From: Shaban, Sundas
Sent: 22 June 2023 14:49
To: _planningadvice
Subject: FW: 22119 - Appn Ref: H23-0356-23 115 Broadgate - barn extension
Attachments: image001_wmz was removed from this message; We sent you safe versions of your files; Dunstable GPDO Appeal Decision.pdf

New Hedge Shown
OUTBUILDING AT 115 BROADGATE,
WHAPLODE DROVE, FOR MR & MRS PEARCE
EXISTING & PROPOSED SITE PLAN

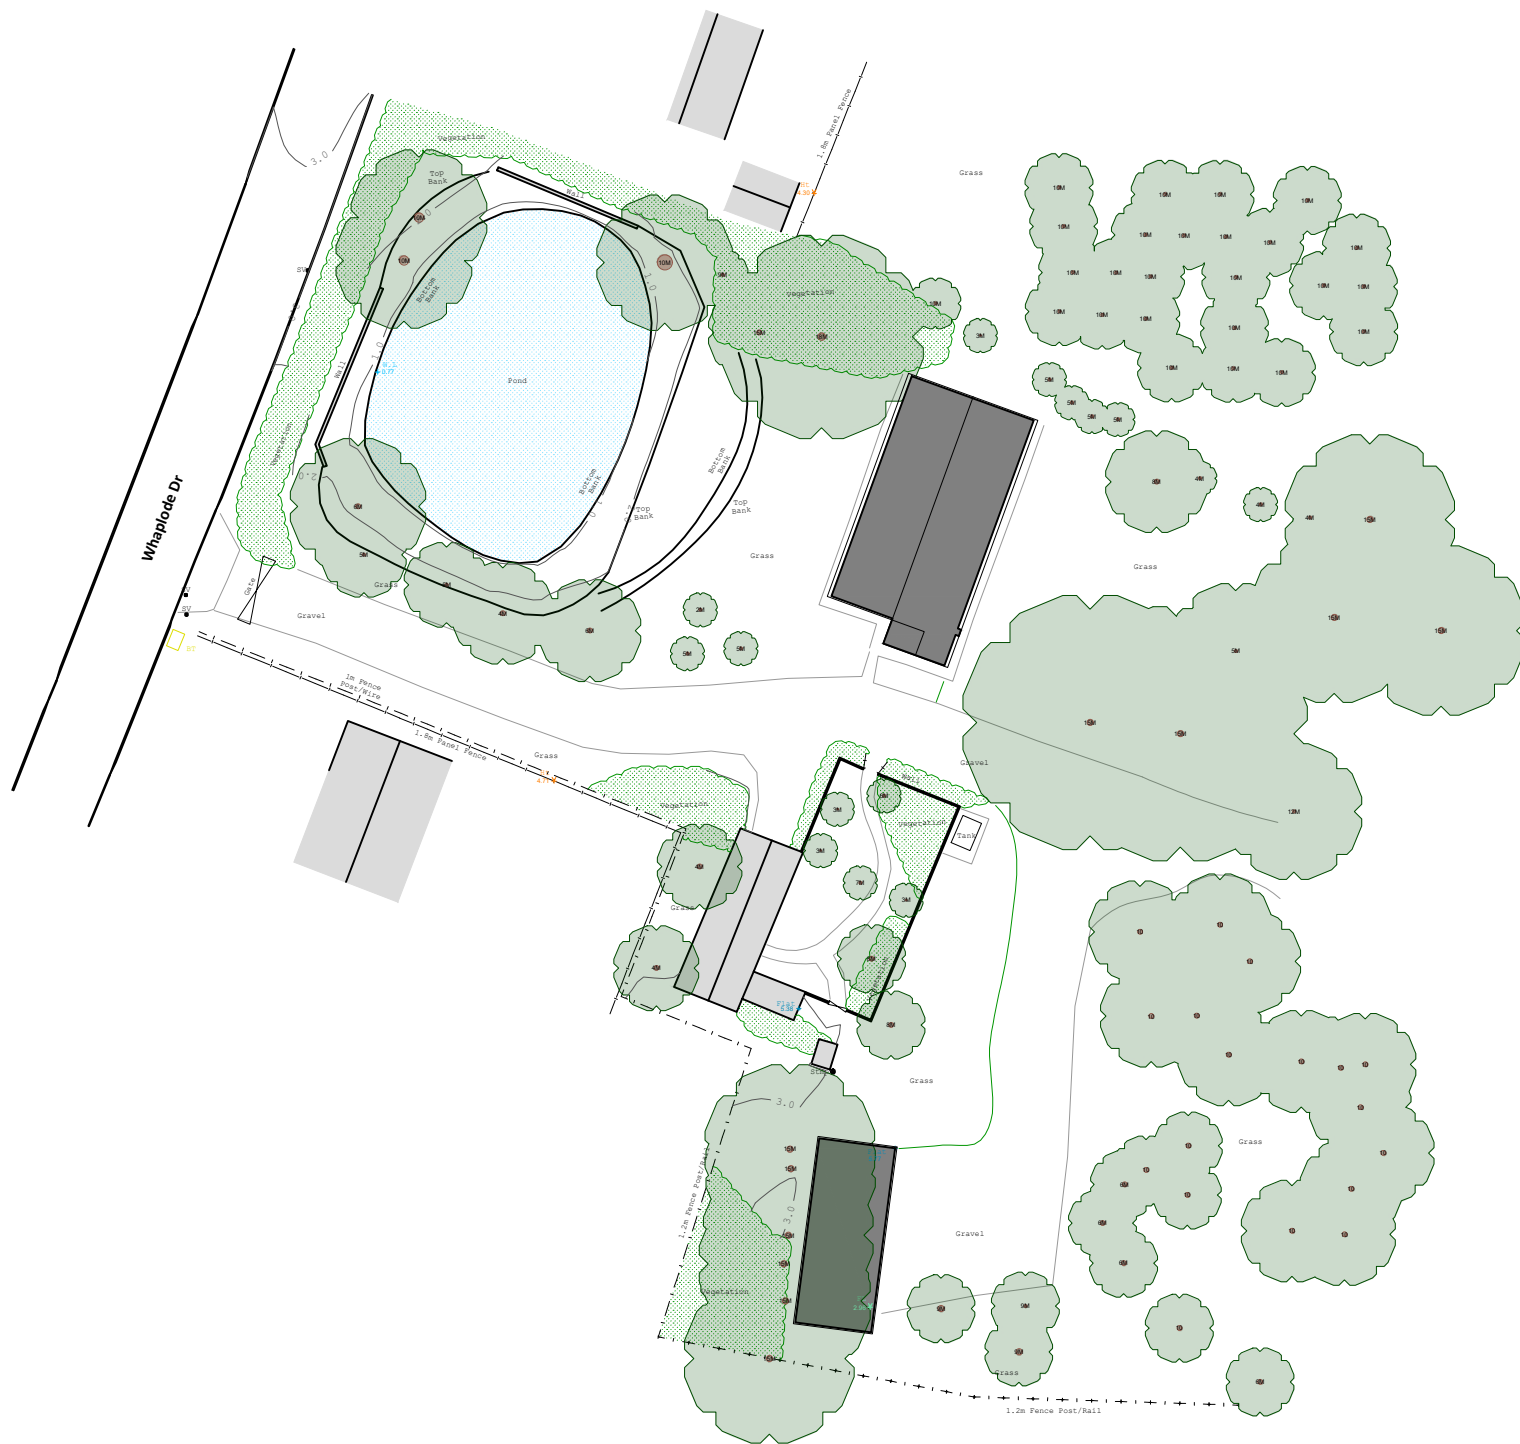
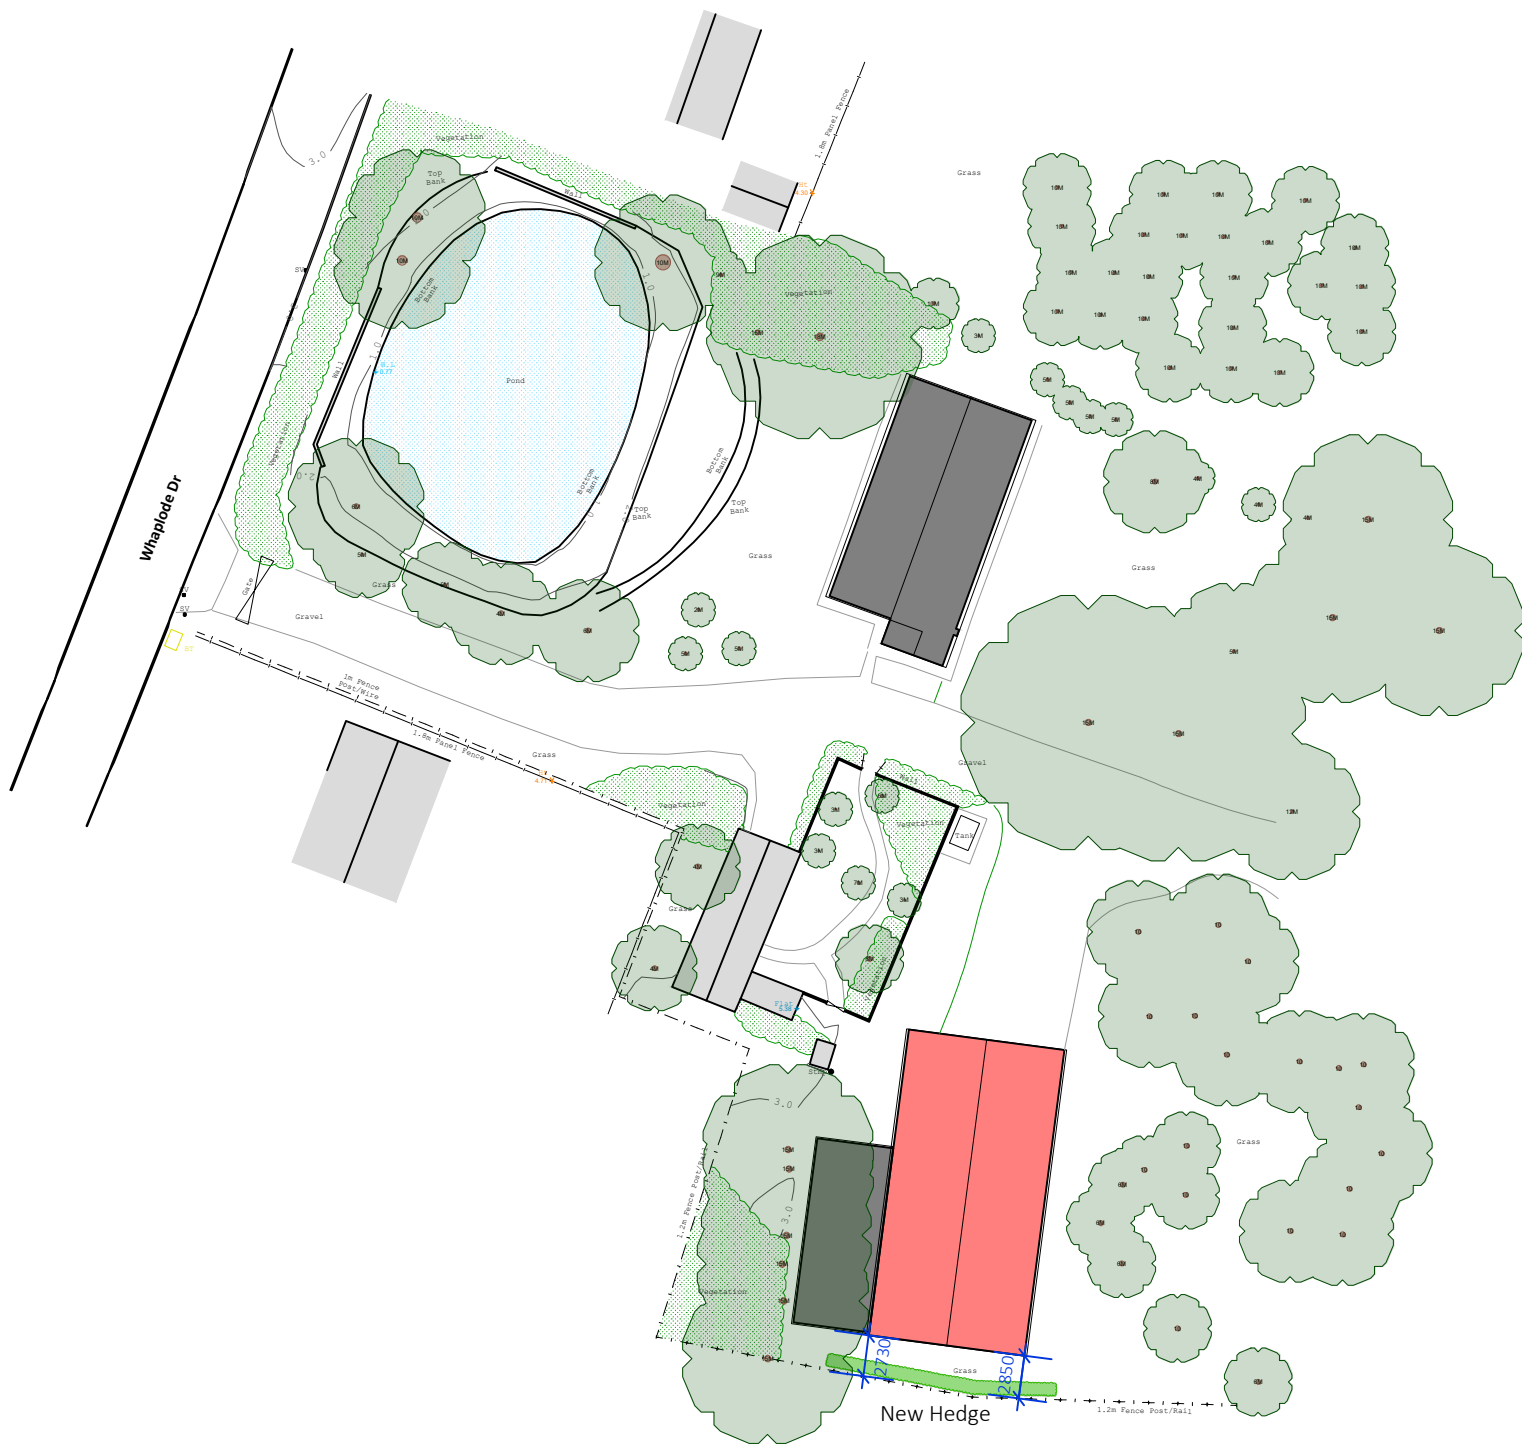
Whilst I understand why your client requires a building of this size, unfortunately in planning terms it is still unacceptable as a domestic outbuilding as it is very disproportionate to the size of the existing dwelling on the site.

As such as advised previously I would suggest reducing its size/height significantly to make it acceptable.

1. We would respectfully submit that, proportion to the existing dwelling is not a material consideration. Schedule 2 Class E of the General Permitted Development Order 2015 permits buildings for the incidental enjoyment of the dwellinghouse to up to 50% of the total area of the curtilage of the dwelling. A building of the **size** proposed would therefore be permitted. I attach, for your interest, a recent appeal decision which considered this issue.
2. It is therefore only the additional height above 4 metres which is the issue. We would remind you that the existing trees on the site exceed the height of the proposed extension and will screen the proposals from views outside the site. The average height of trees shown on the site plan is 10m with some up to 15m in height.
3. The proposals are not dissimilar to the size of a typical agricultural building common in this rural area.
